DRB Application No.: 06DRB-01130 (P&F)

Project # 1004880

Project Name ROSITA ADDITION

**CITY OF ALBUQUERQUE
PLANNING DEPARTMENT
August 16, 2006
DRB Comments**

Plat of
 Parcel B-1, Block 4
Rosita Addition
 Albuquerque, Bernalillo County, New Mexico
 August 2006

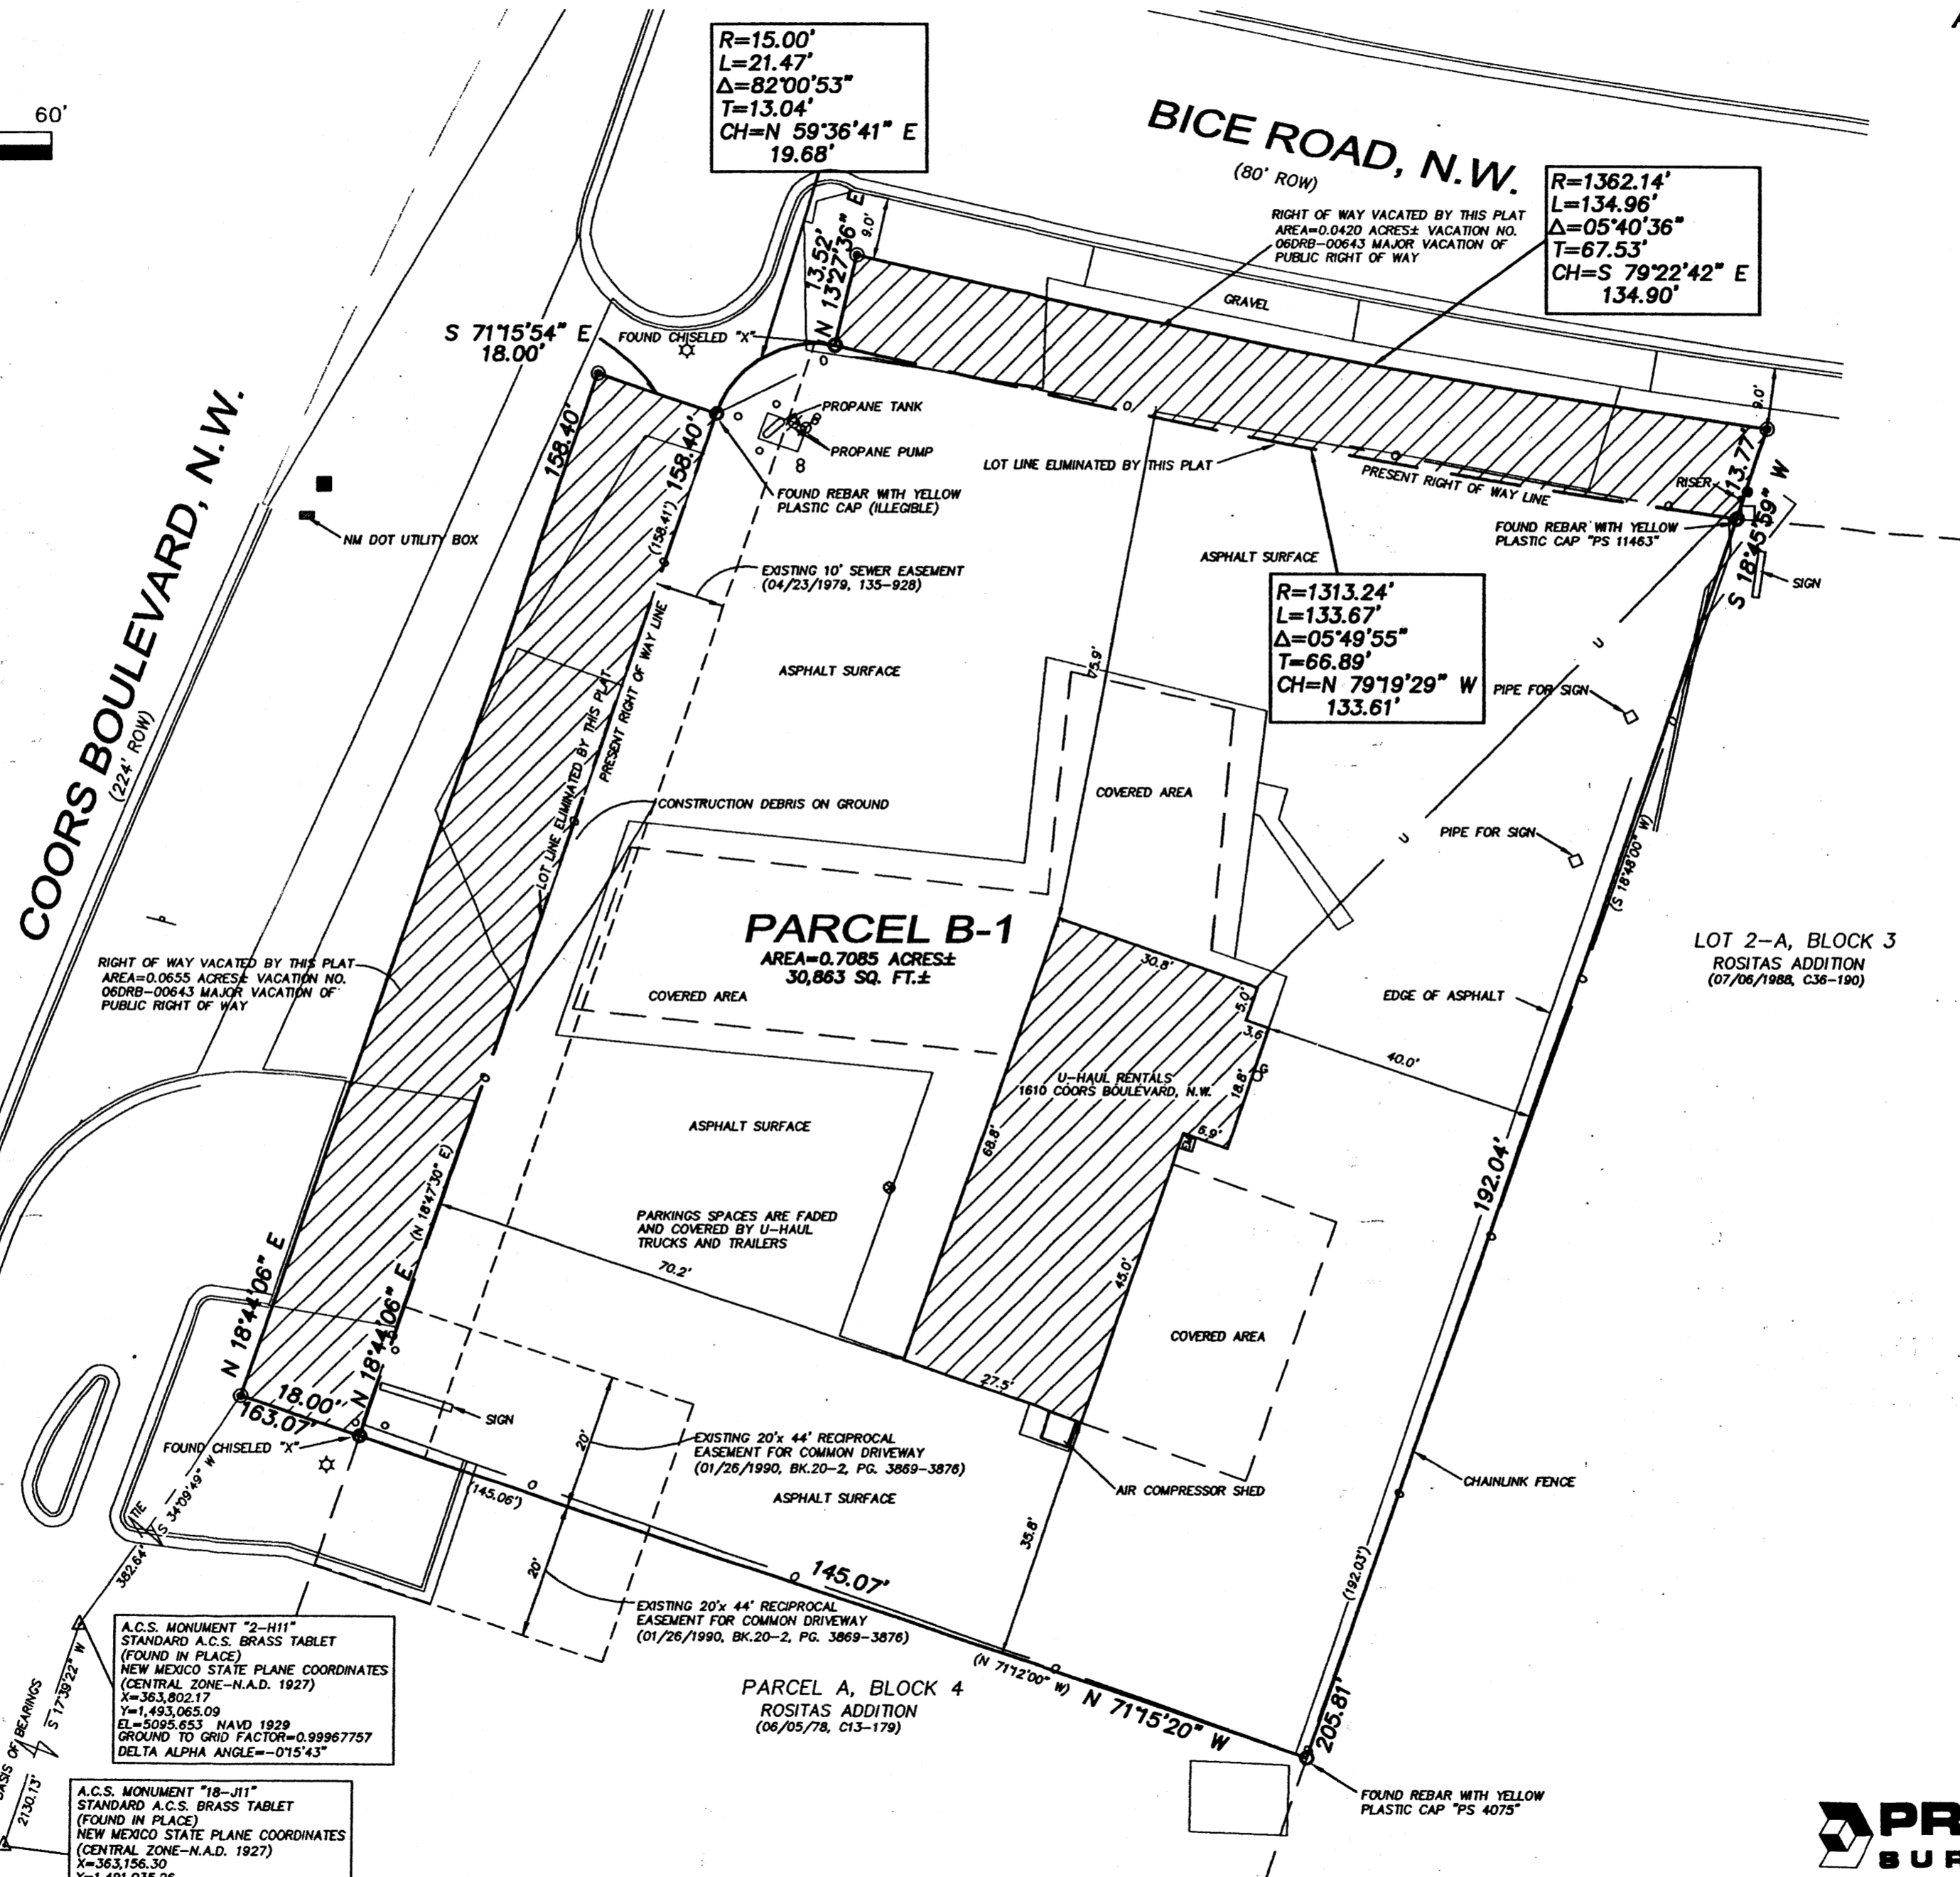
- CITY ENGINEER / AMAFCA: SD esmt & WL to SAS
- _____
- _____
- _____

Need to retain a public storm drain easement centered over the existing facility.
Take delegation.
